Your Ref: OWPC18374
Our Ref: EP/58/18/HH 29-03-2018
Please ask for:
Andrew Wood

Front/rear extensions, raising height of existing roof to create first floor & boundary wall & electric gate to front of site. This application also lies within the parish of Rustington.

The Price of Peace 45 Angmering Lane Rustington

Thank you for your internet representation made on 23rd May 2018 which has been recorded as '**no objection**' with the comments as follows:

PROPOSED SOUTH ELEVATION 1:100

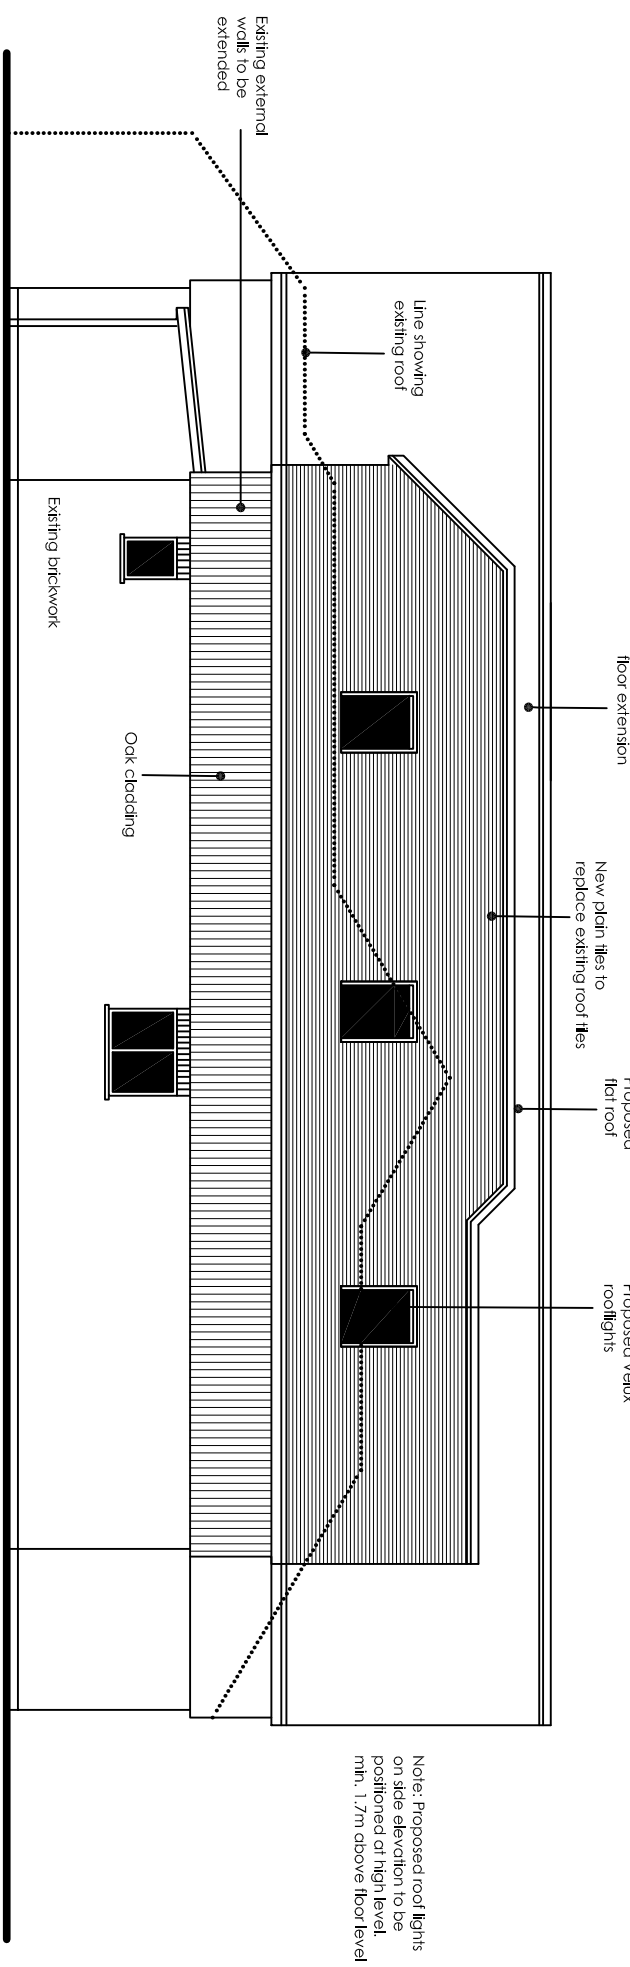
Having viewed the plans my main concern centred on the three Velux windows on the south elevation of the property, particularly the two nearest to the rear garden because they would overlook my patio. I discussed my concerns with Mr. Nash, who agreed to make the Velux window on the south west corner non-opening and glazed with frosted glass. He also agreed to glaze the middle Velux window with frosted glass but I conceded that this window would need to be the opening variety since it served a bathroom. If this agreement holds then I have no objections or further comments. There is currently nothing in the plans to reflect our agreement but I have no reason to think that Mr. Nash is not a man of his word and will not honour his promise.
